LSC Responses to TIS Redline Comments

Silverado Ranch, Filing 2 Transportation Memorandum (LSC #S224530) January 30, 2024

Entering Sight Distance Analysis for Passenger Cars

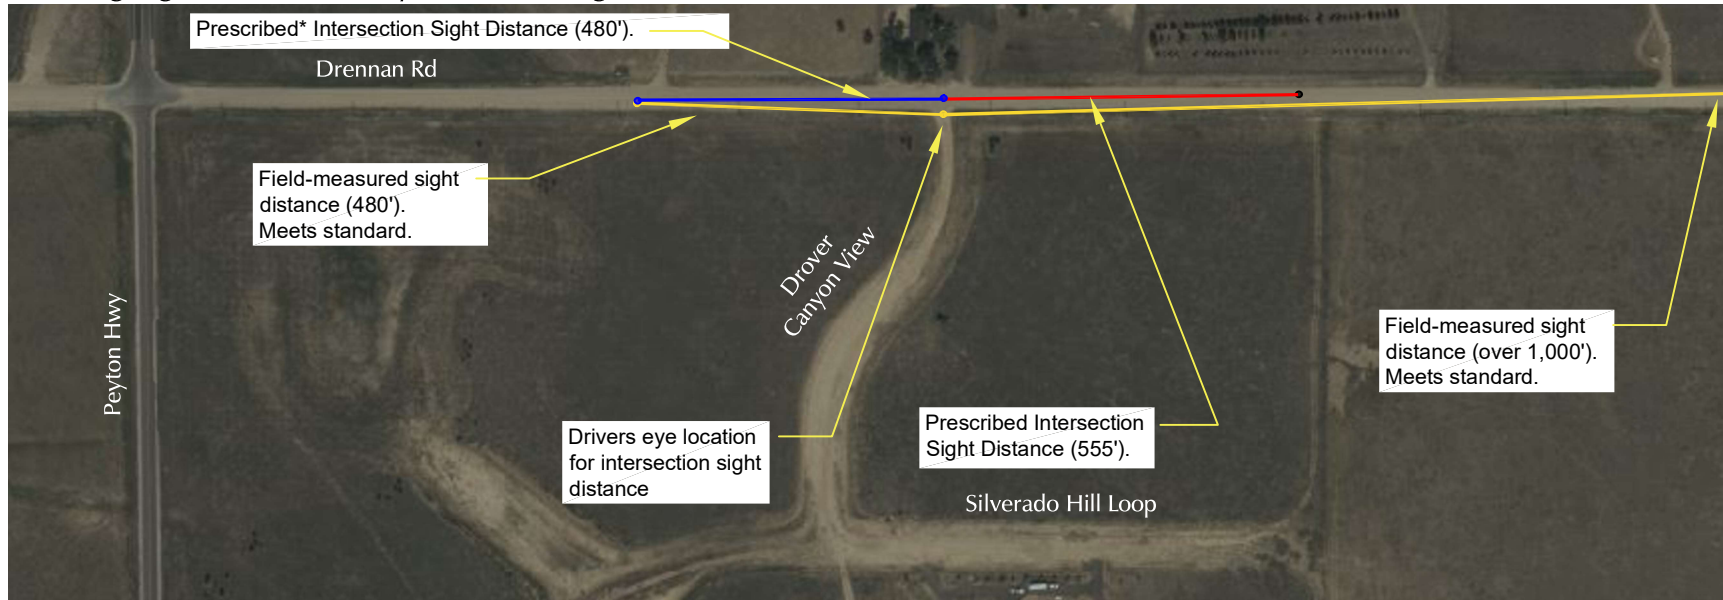
Provide a figure for sight distance and stopping sight distance at intersection of Drennan Rd and Drover Canyon View

LSC Response: A sight-distance Figure has been included in the updated TIS.
